# CITY OF ALBUQUERQUE

June 12, 2019

**Re:** Water Authority Customer service and Operations facilities  
**6000 Alexander Blvd NE**  
**Traffic Circulation Layout**  
Engineer's/Architect's Stamp **05-09-2019** (F16D014C)

**TCL-101**

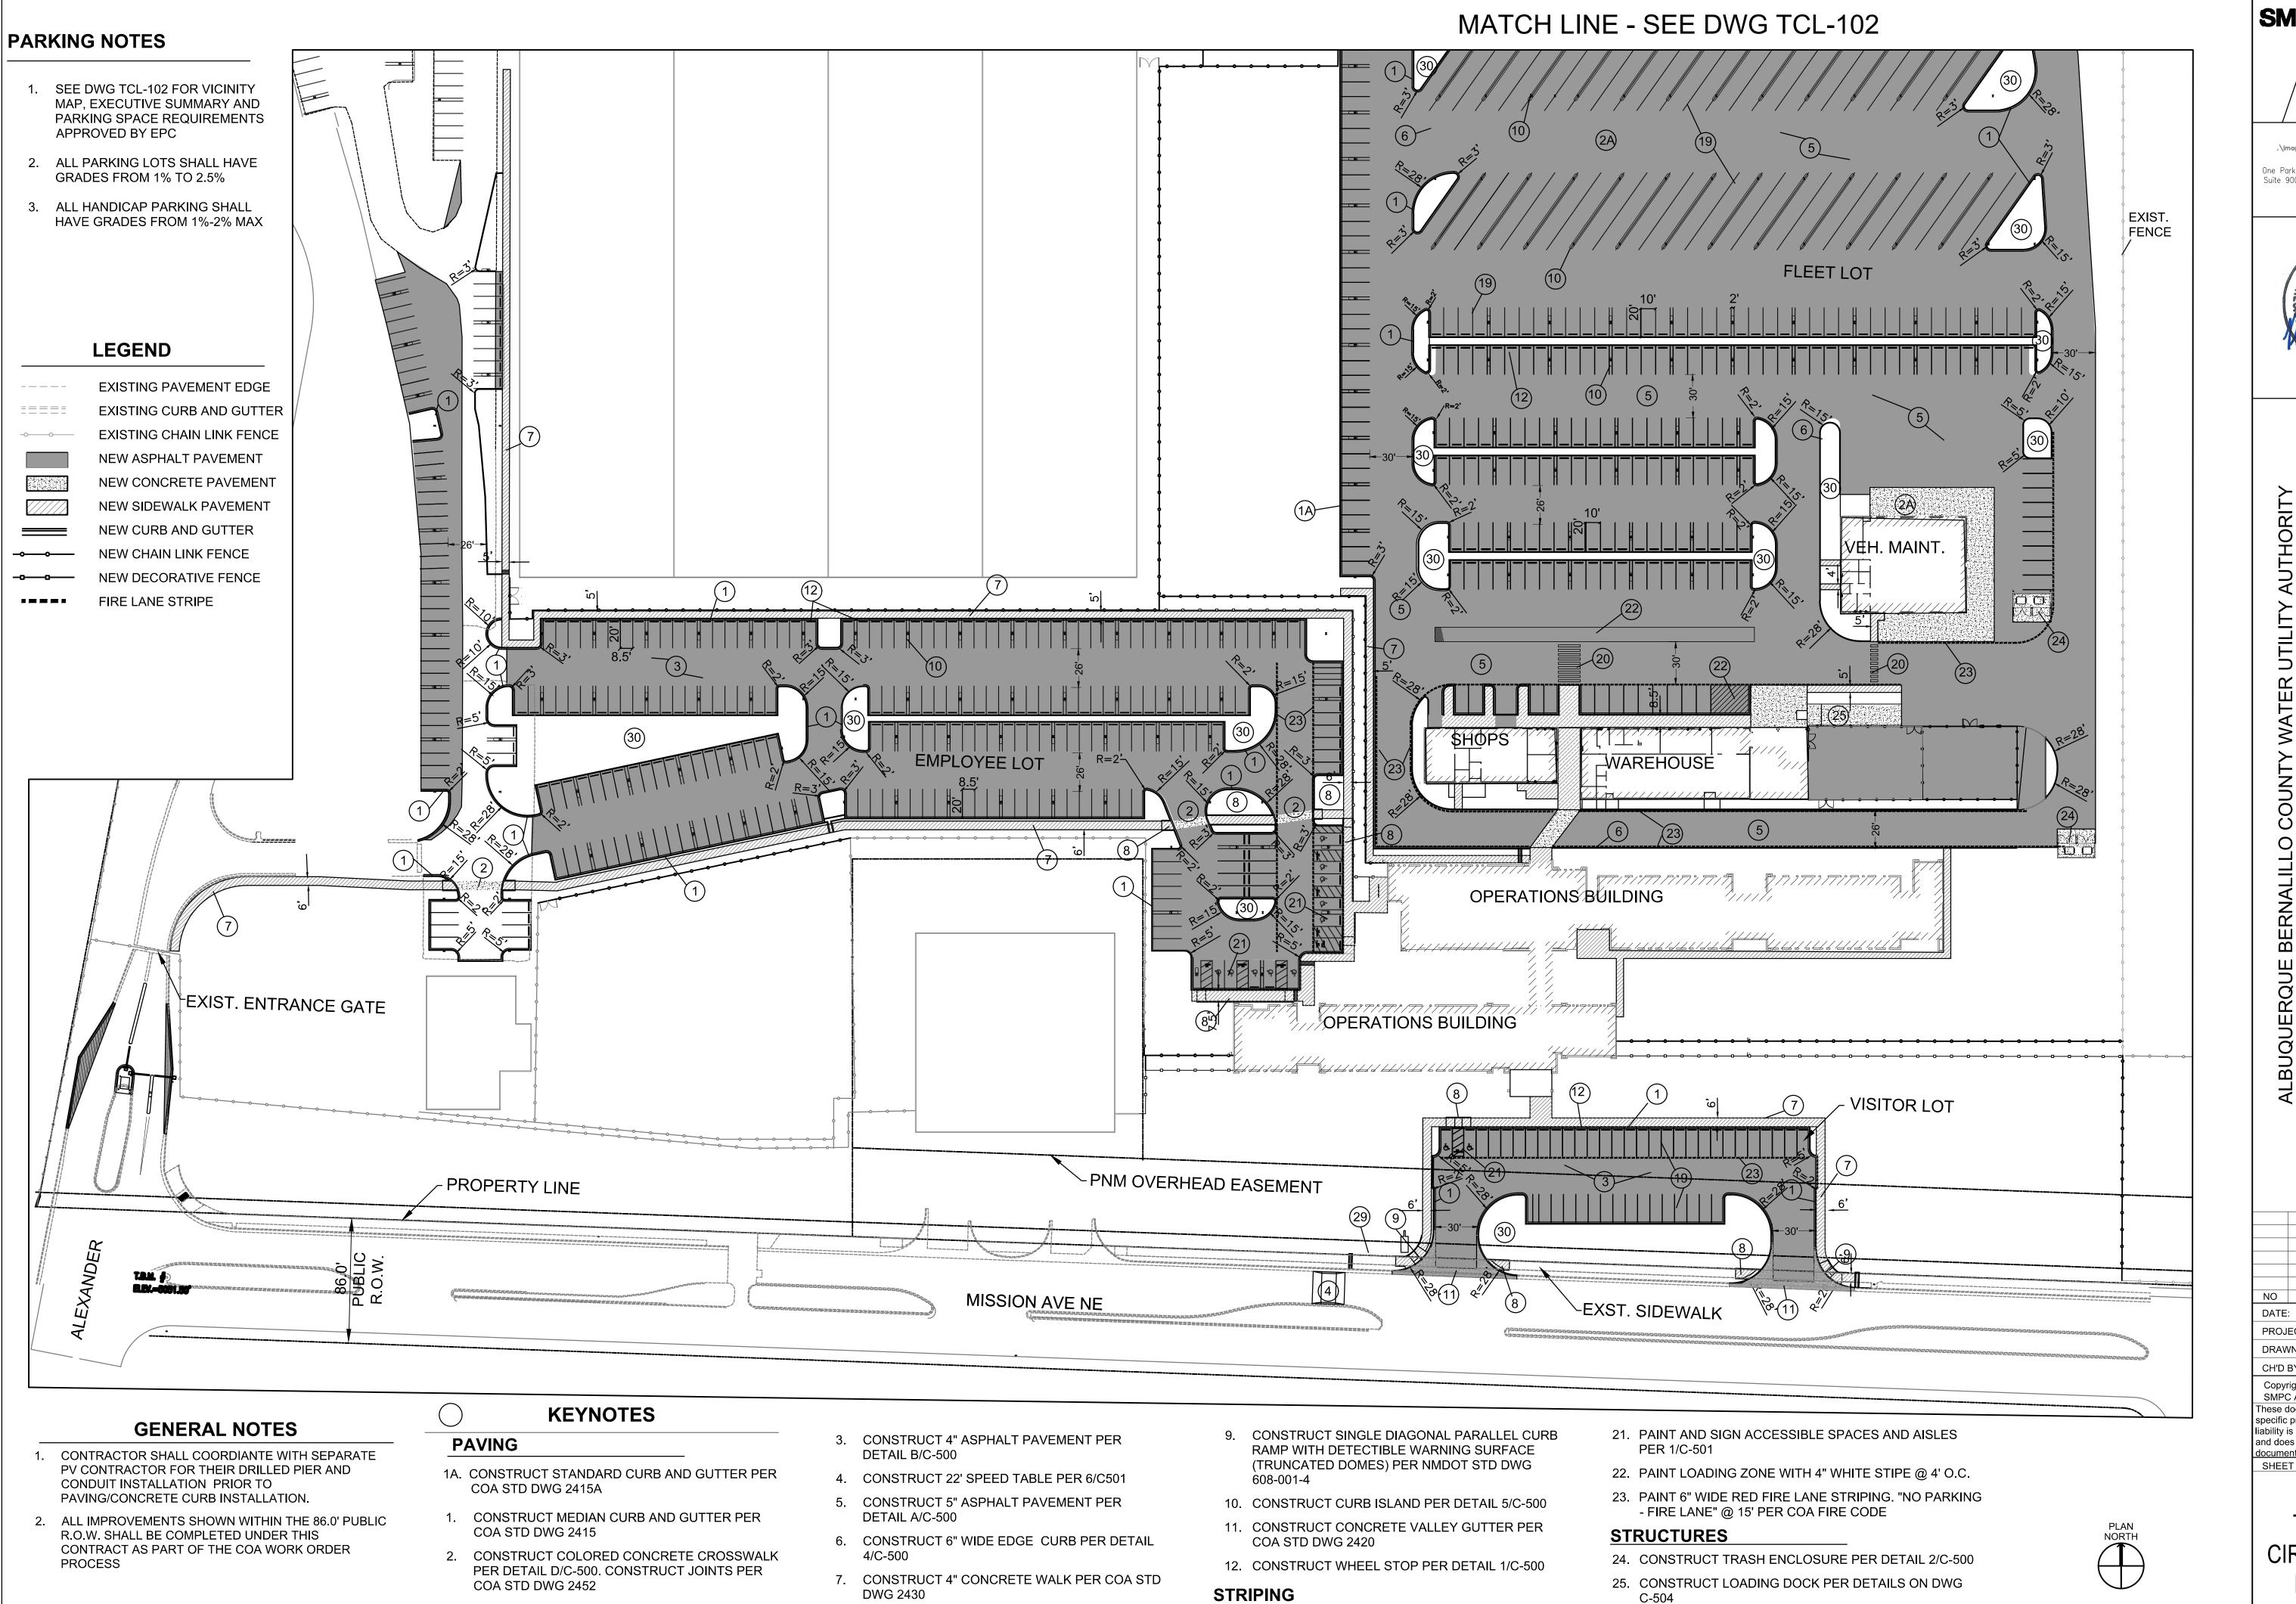
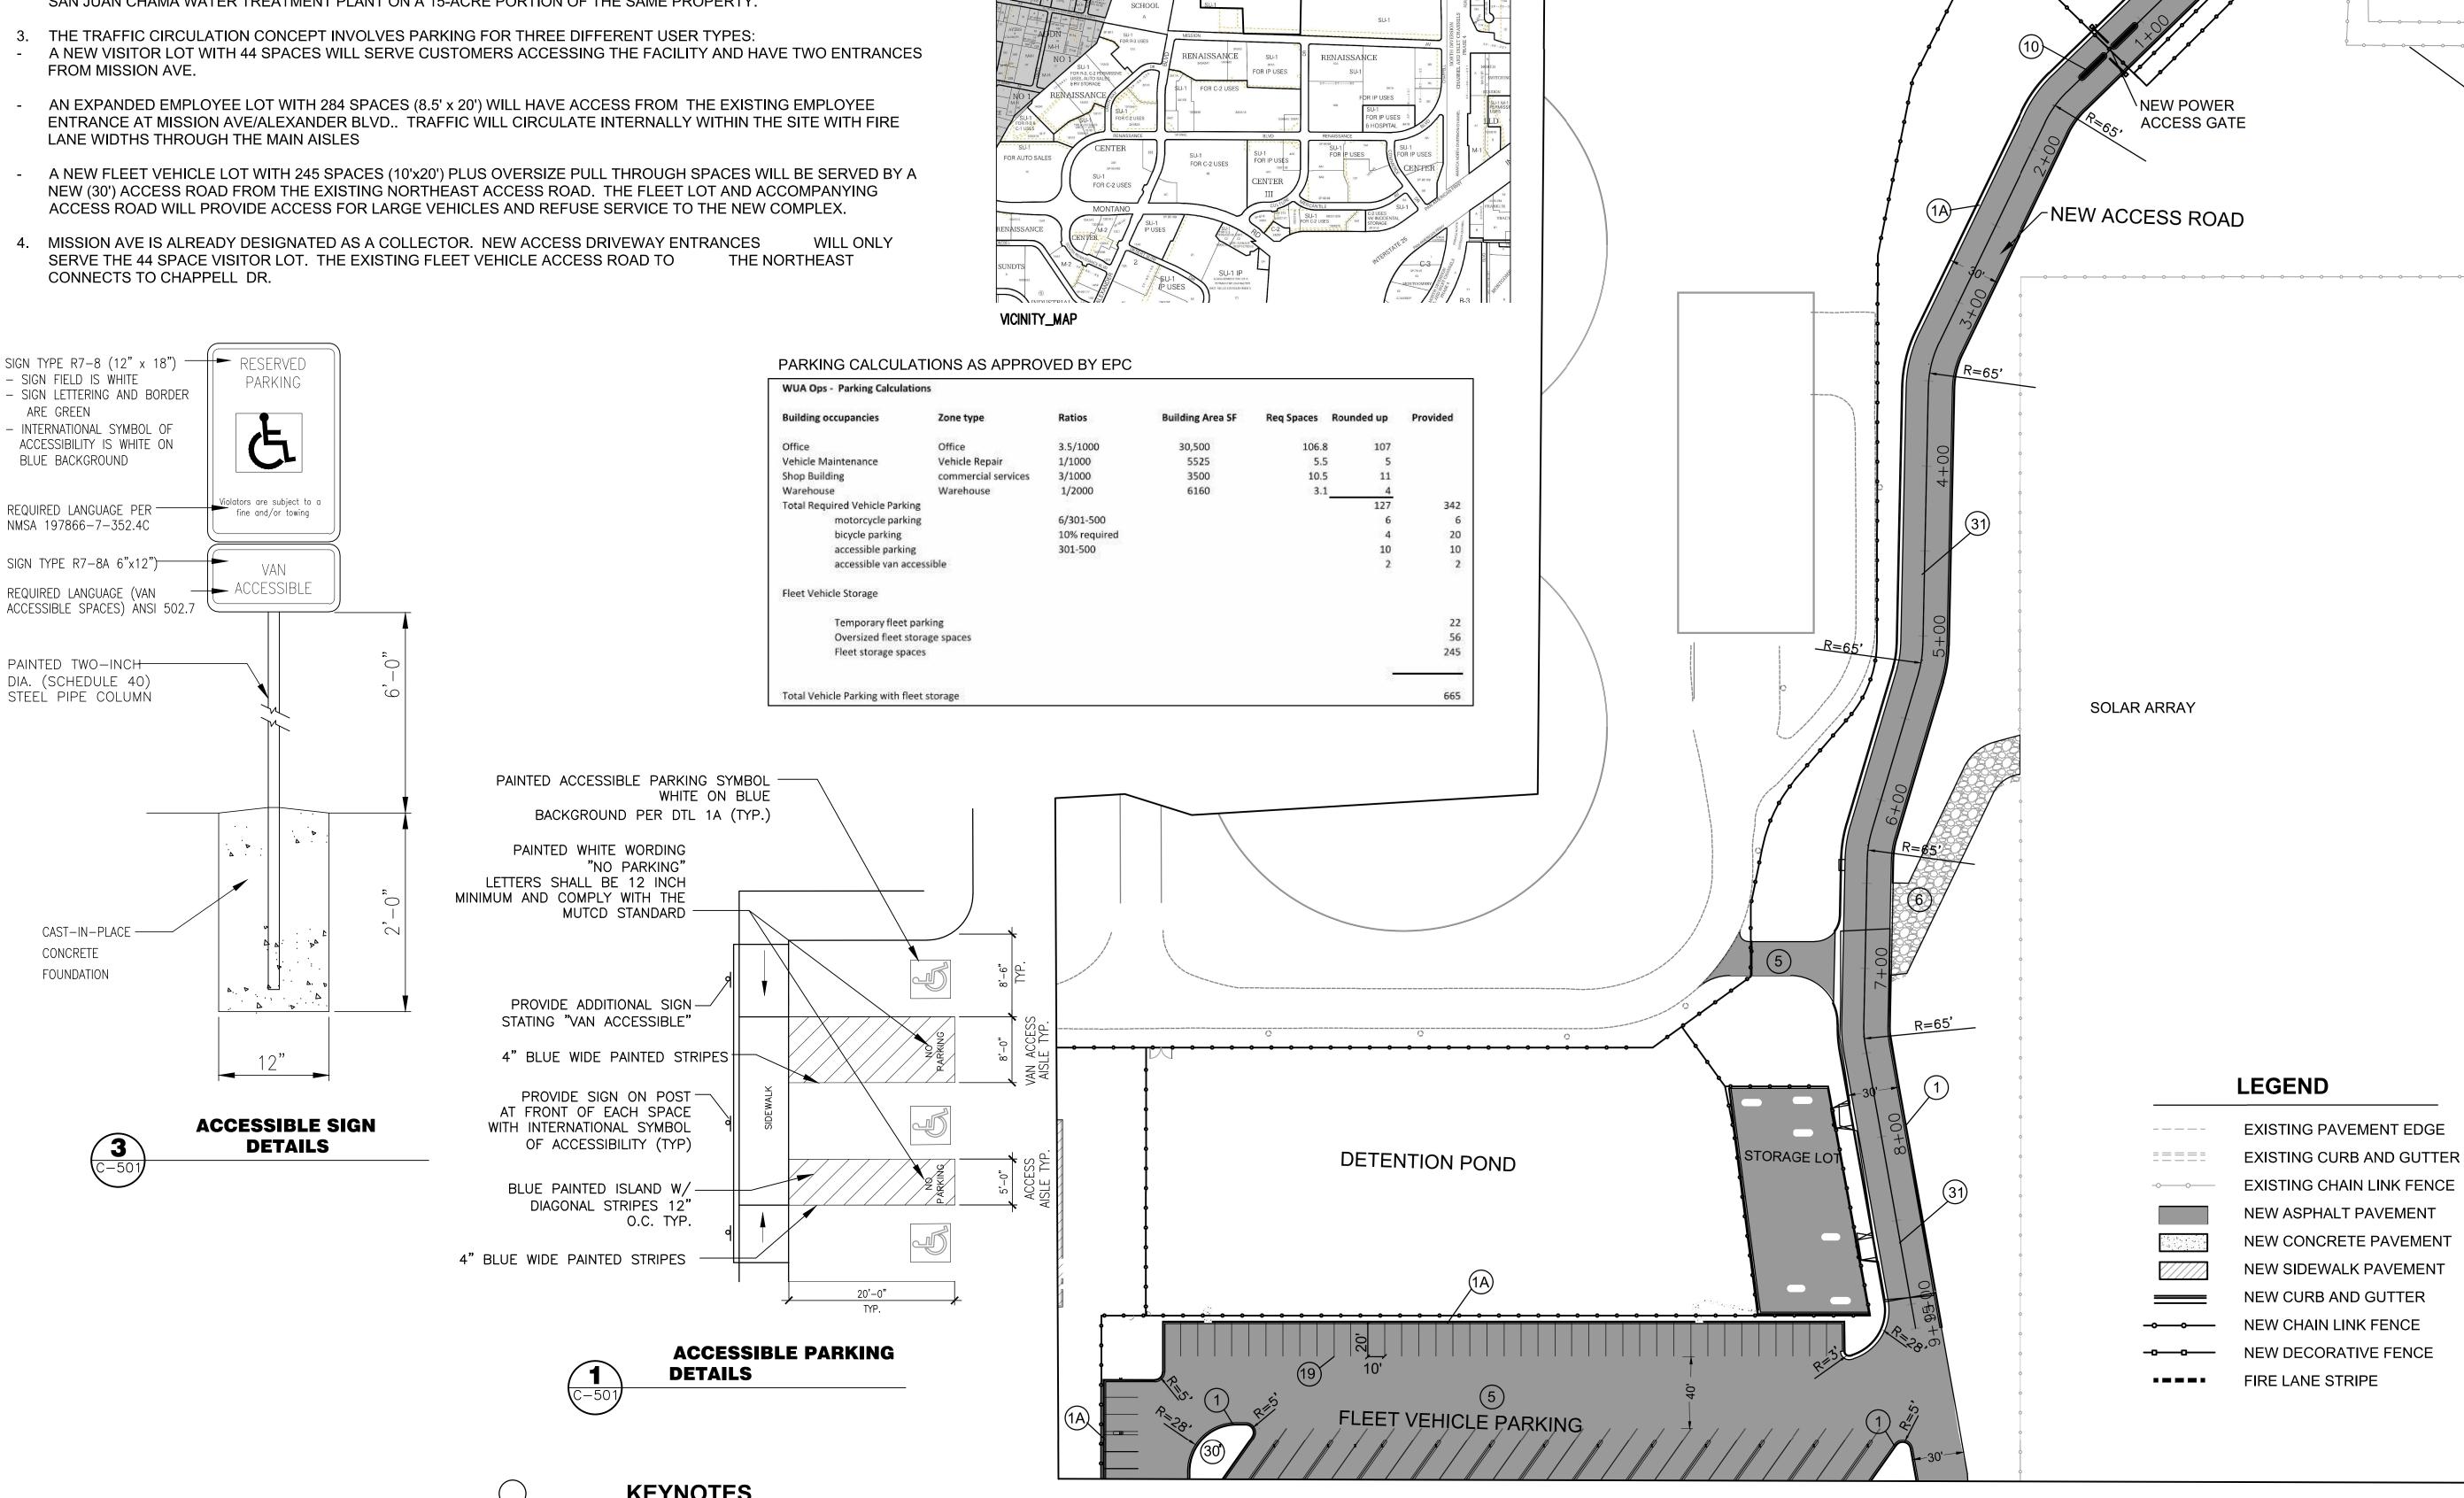
1. provide a copy of refuse approval.
2. Please remove all the fire lane stripings that are not along the curb. ( Keyed note # 23)
